CITY OF ALBUQUERQUE

August 14, 2020

RE: Kraemer Fields
2801 Karsten Court SE
Grading & Drainage Plan
Engineer's Stamp Date: 07/31/20
Hydrology File: M14D012J

STORM
PLAN AND PROFILE
LOT 2B

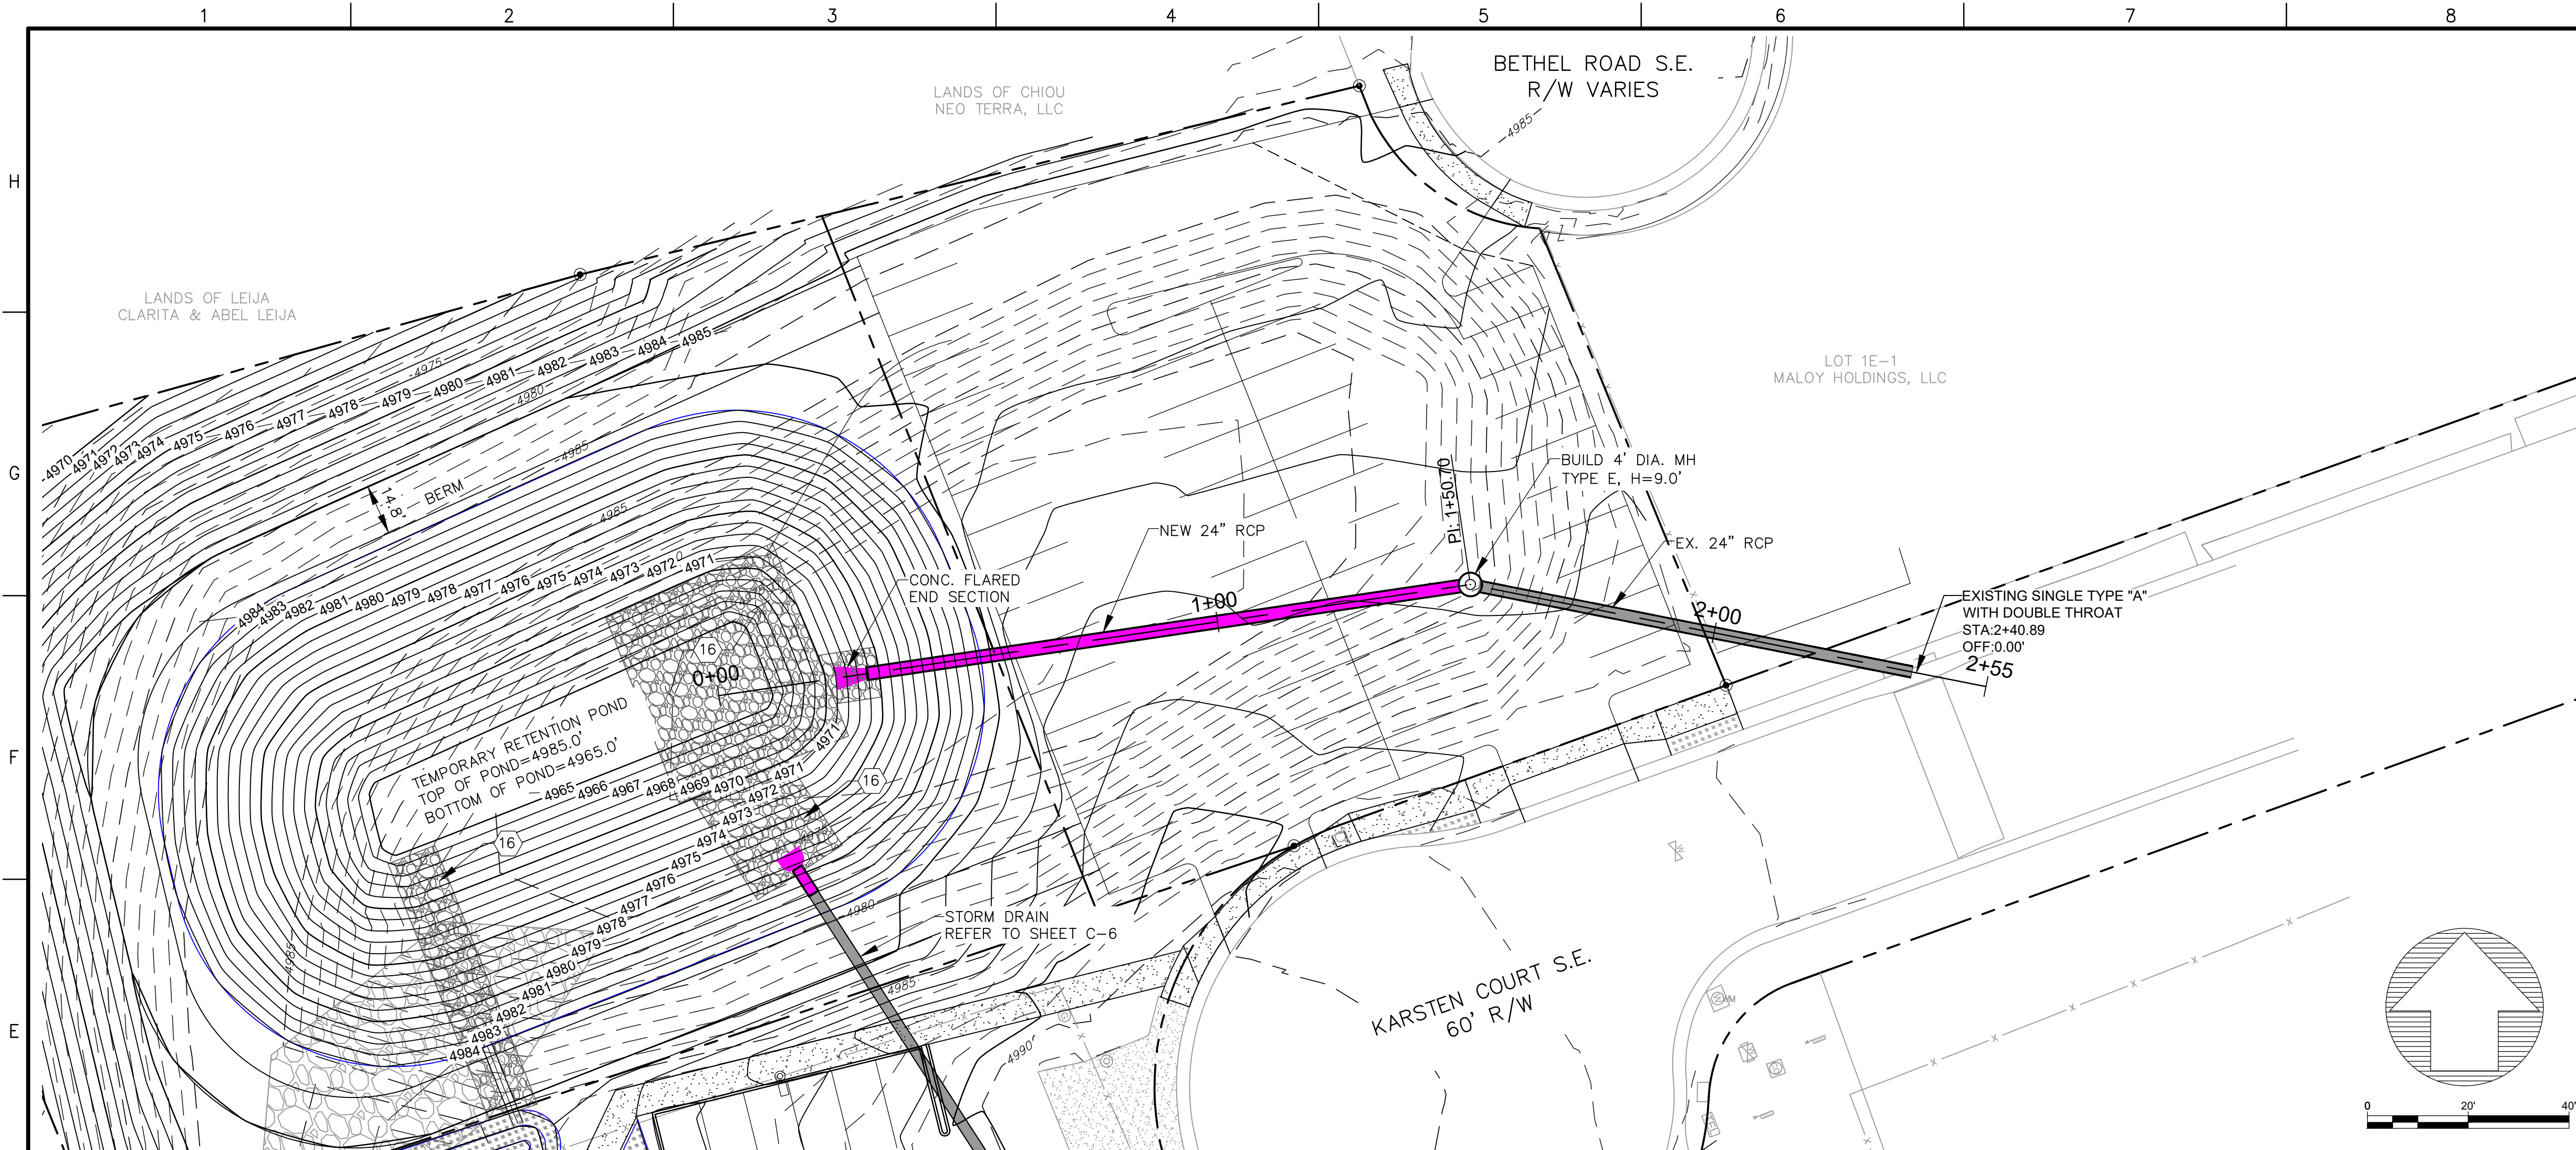
5. Sheet 1. Please show the existing pipes that are to be removed and label them as being removed.
6. Sheet 1. Please provide all information on the proposed storm pipe system. (pipe invert elevations, MH top of rim elevations, inlet rim elevations,, and for the pipe sizes and lengths.

7. Sheet 1. Provide hydraulic calculations per Article 6-10 of the DPM for this proposed storm drain system, calculated along the Energy Grade Line; include both the HGL and EGLs in the table.

SHEET TITLE
STORM
PLAN AND PROFILE
LOT 2A-1

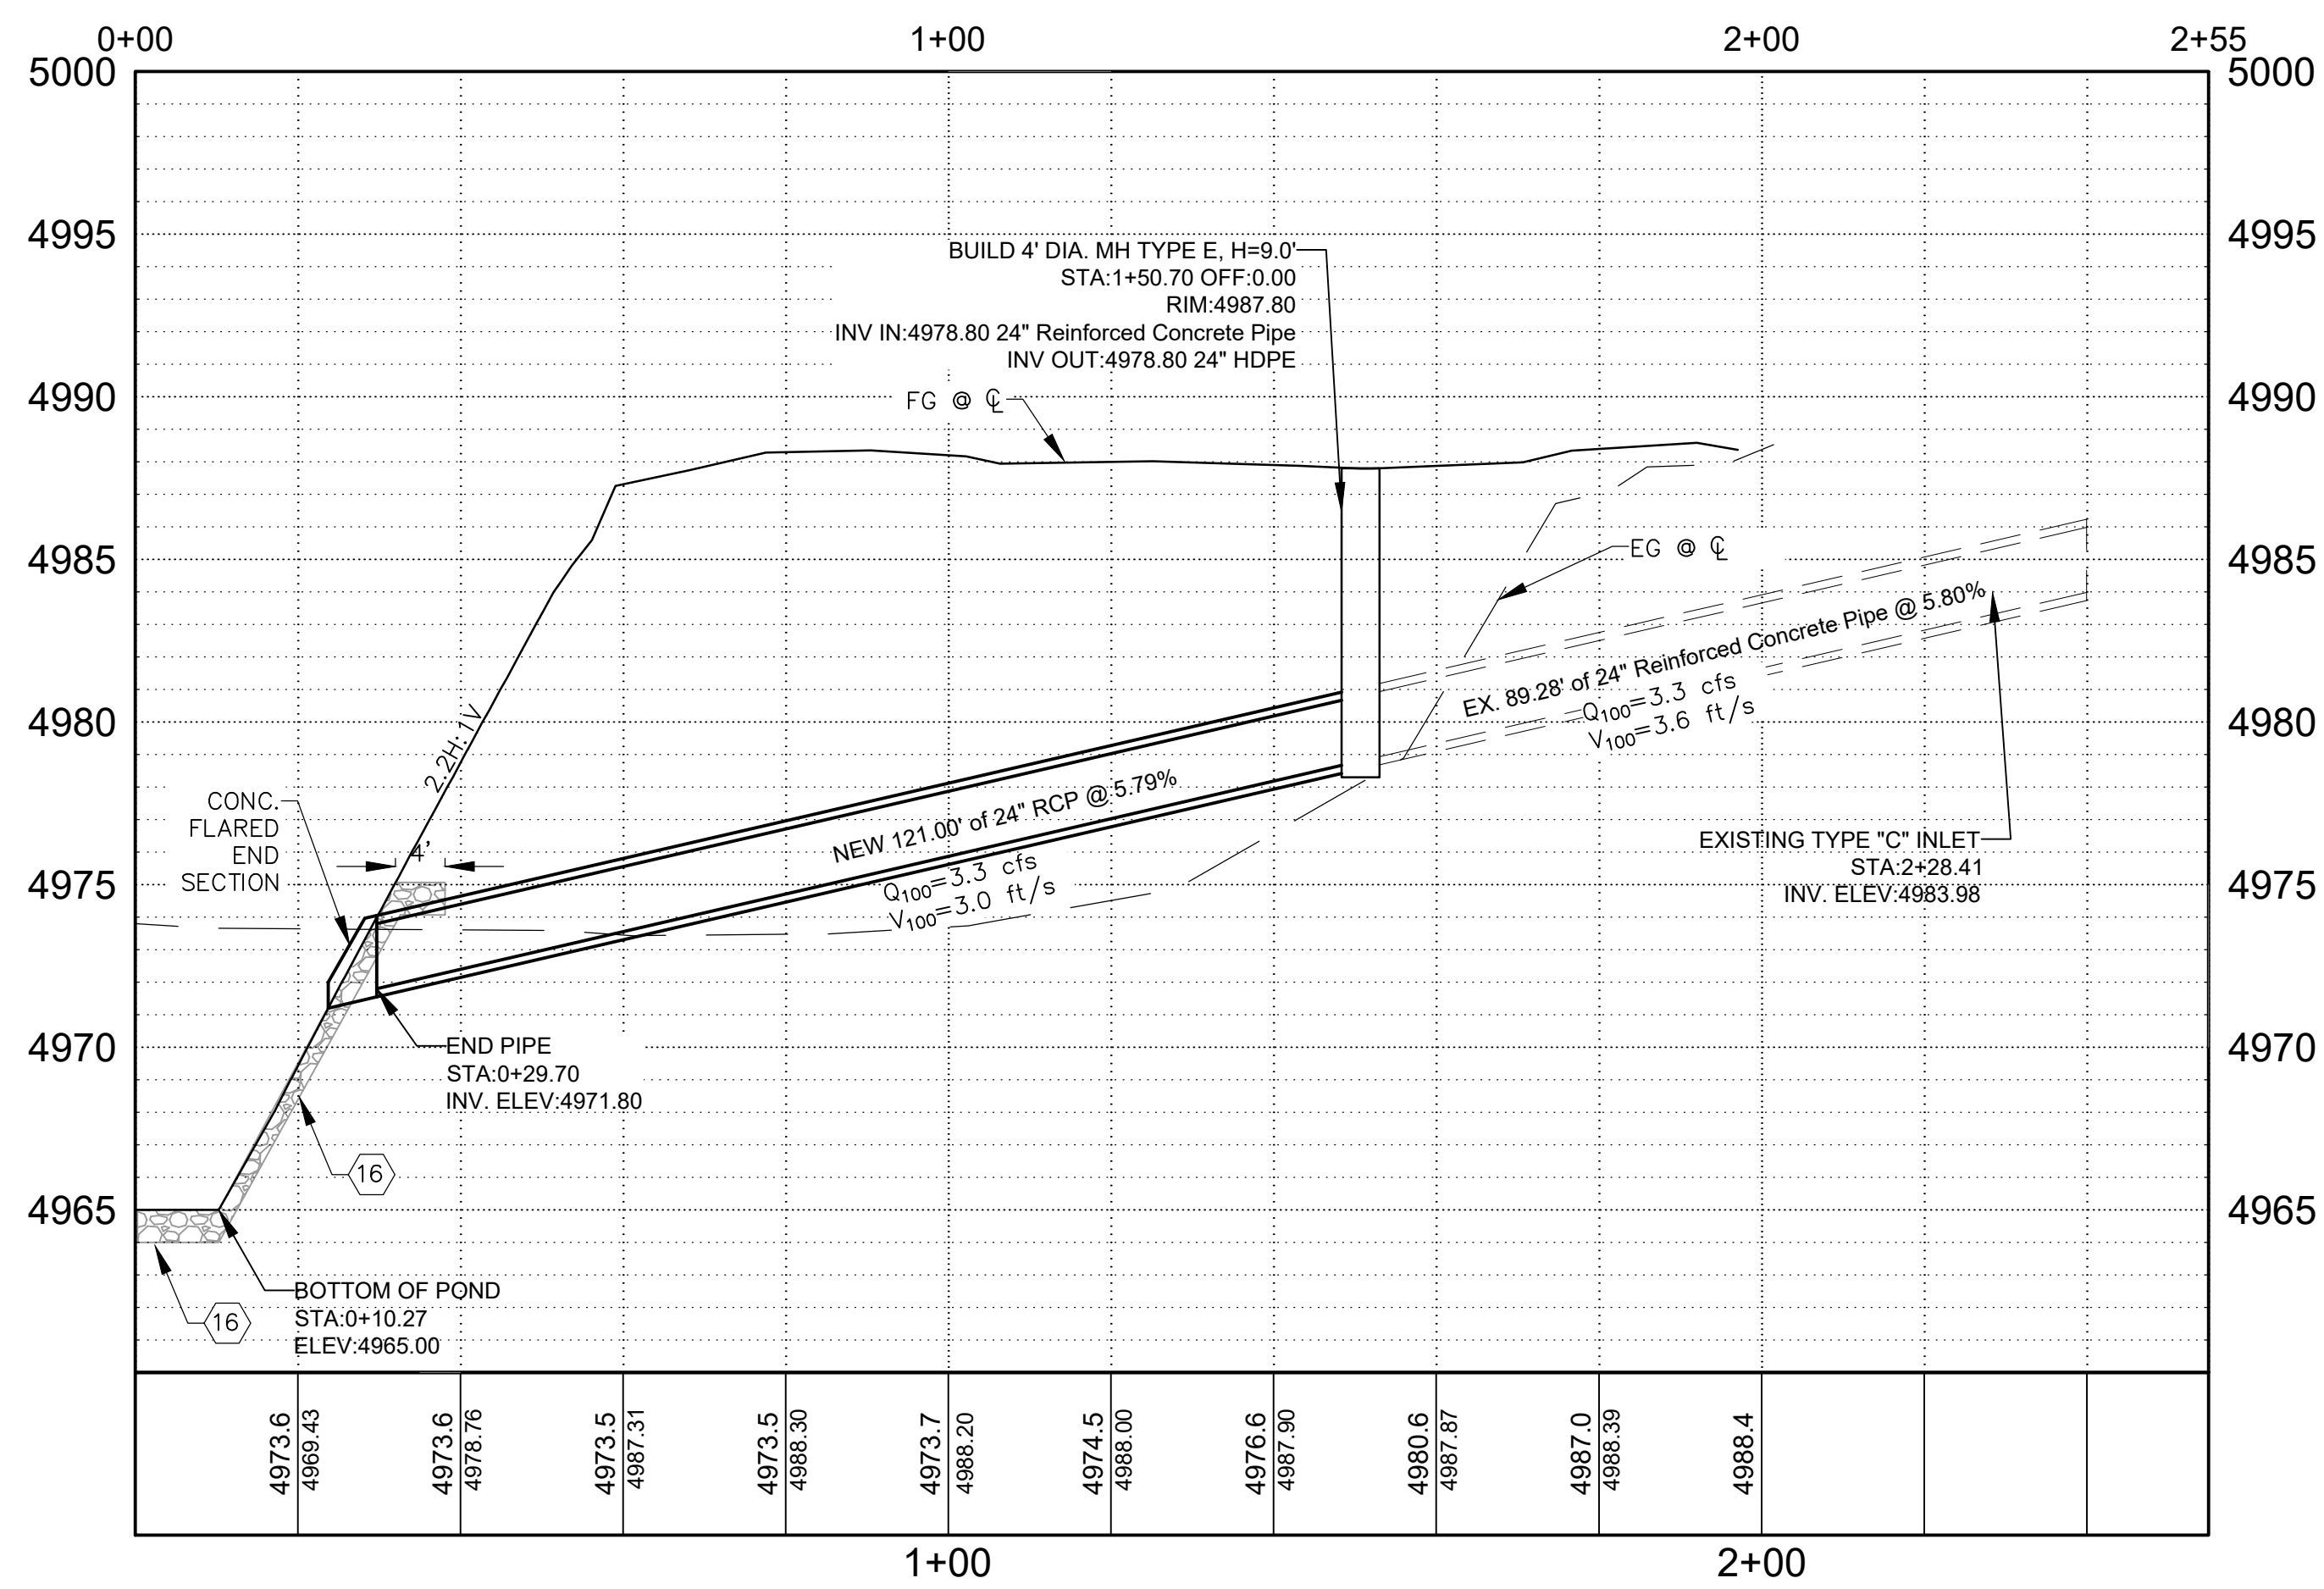
8. Sheet 1. Please provide a detail for the pipe outfall into the retention pond.
9. Sheet 2. Please provide the WSE of the 100 year 10 day volume in all sections.

PROPOSED
BASIN MAP
LOT 2A-1

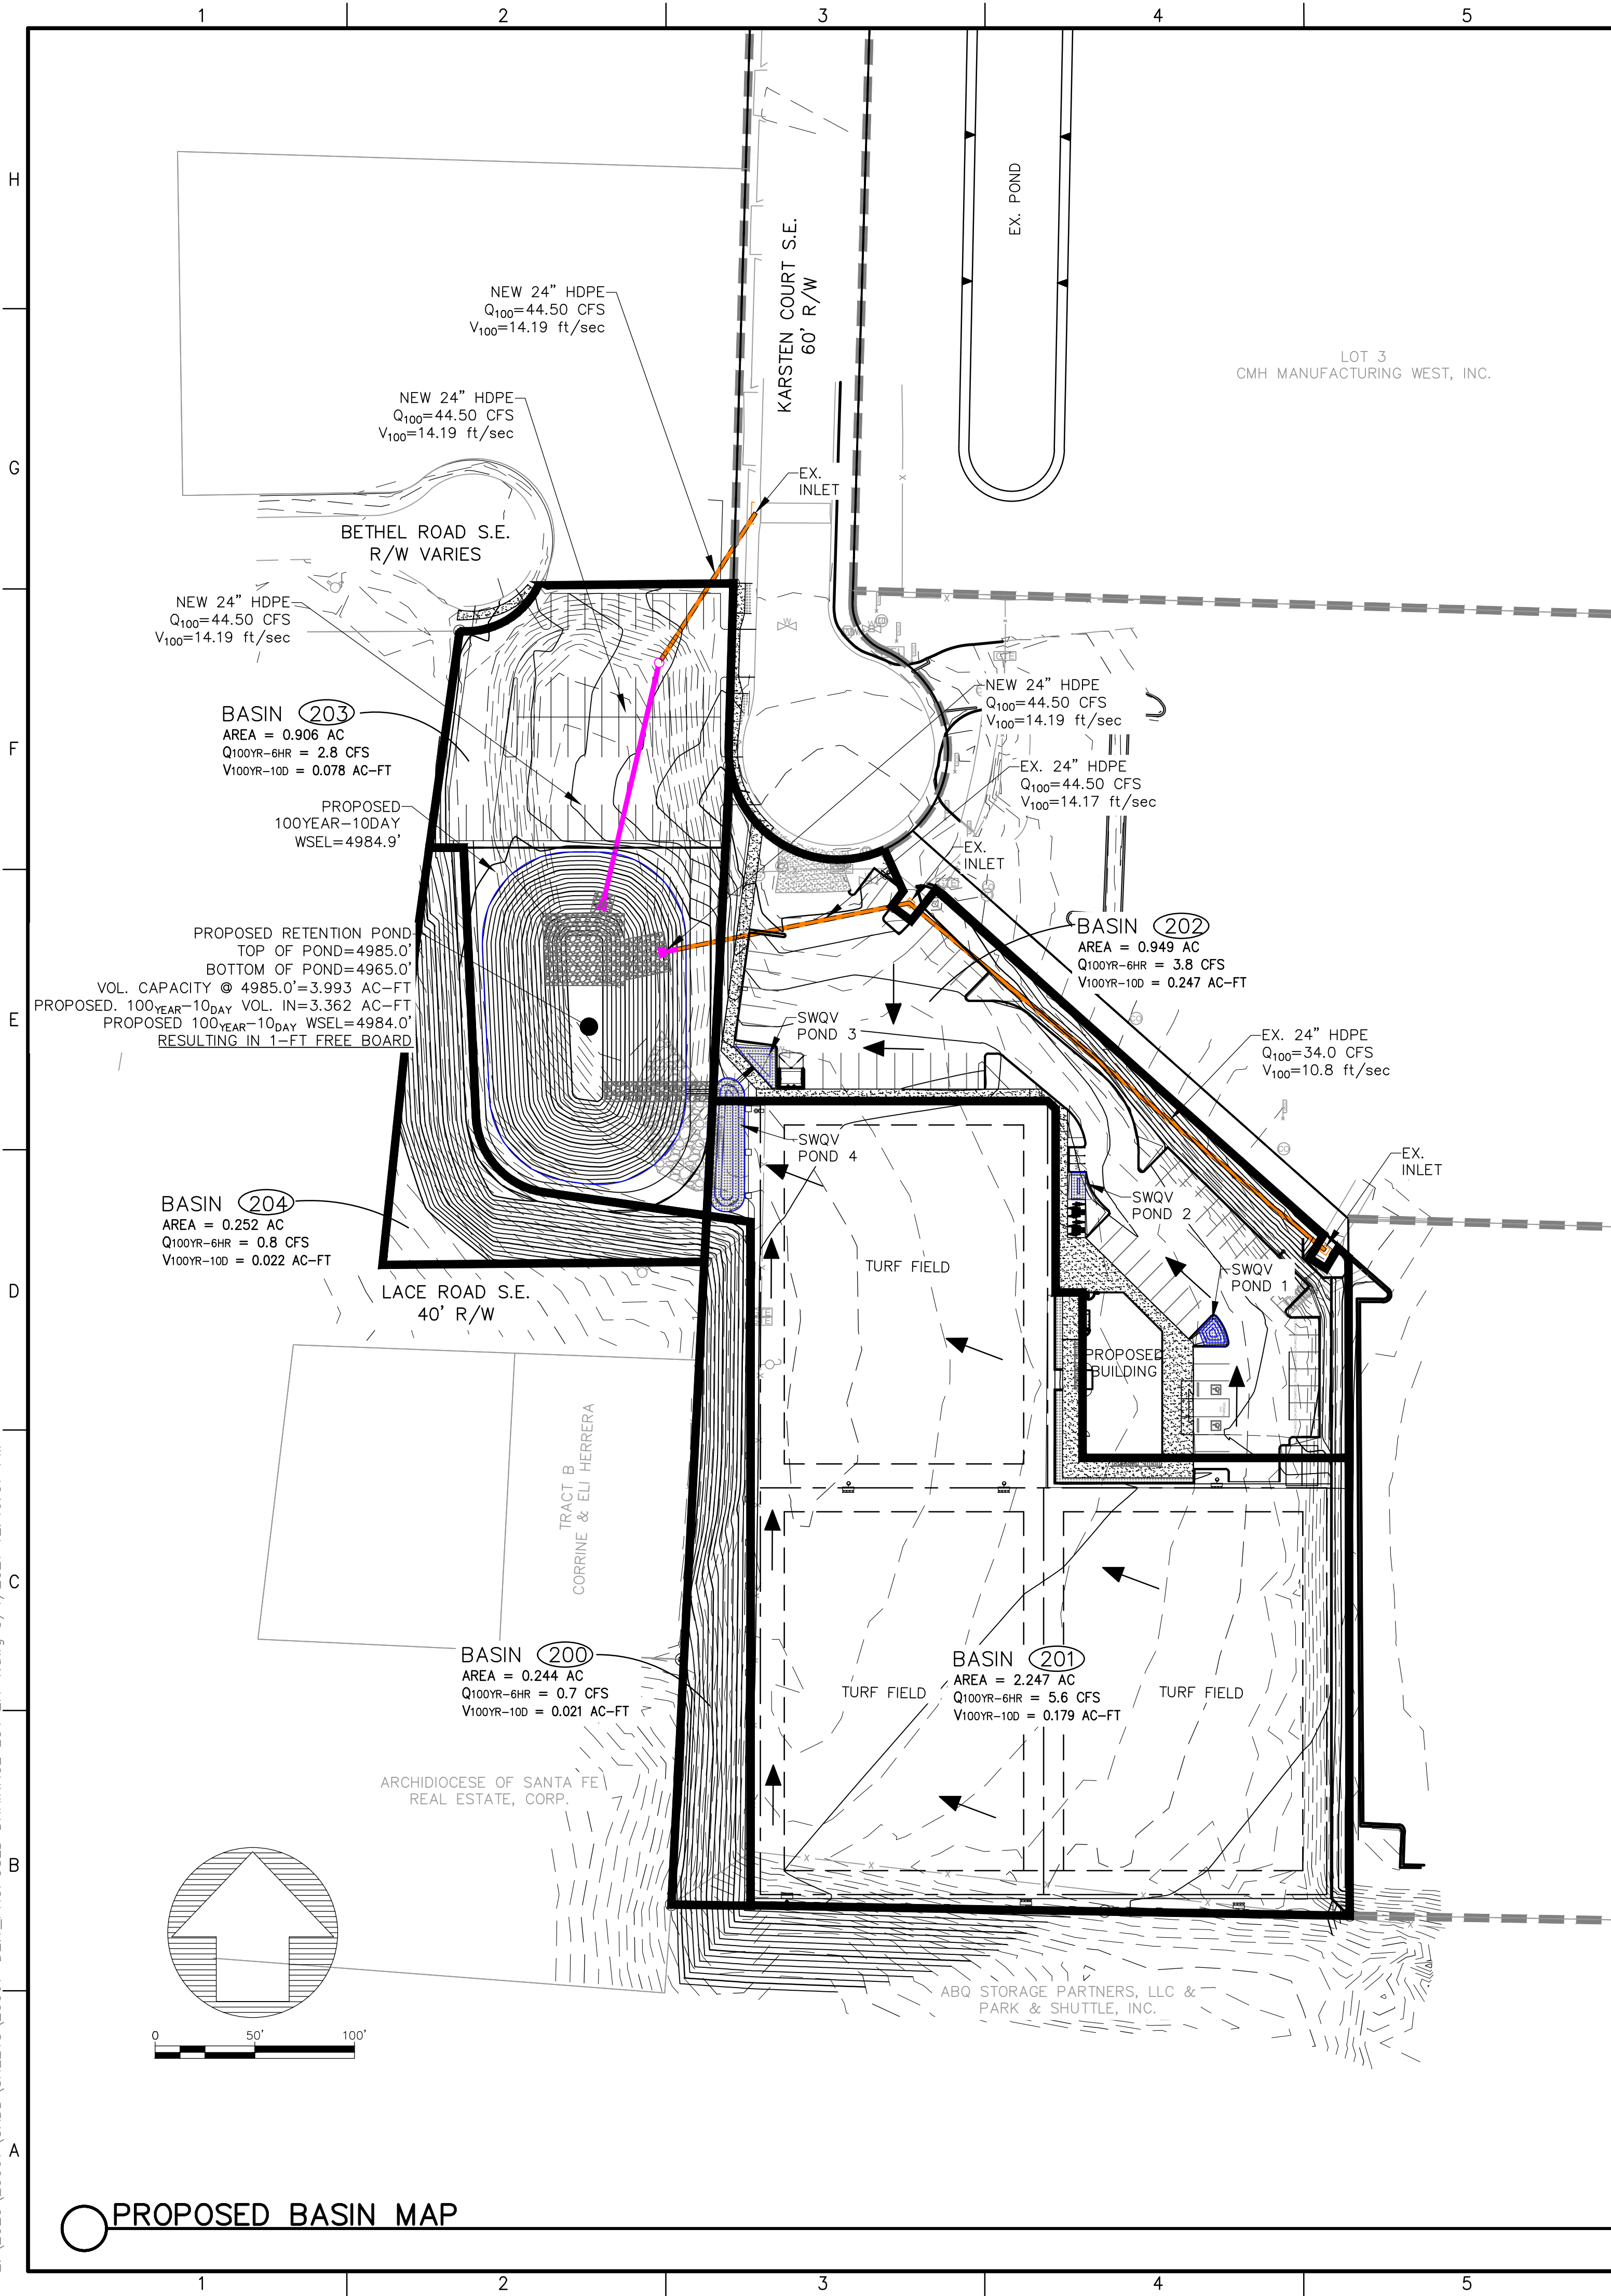
10. Sheet 2. .Please provide an approved City method to water proffing the retaining wall below the WSE of the 100 year 10 day volume.
11. Sheet 4. Basin 300 needs drain into the proposed storm drain as outlined in comment #4. Please show this.
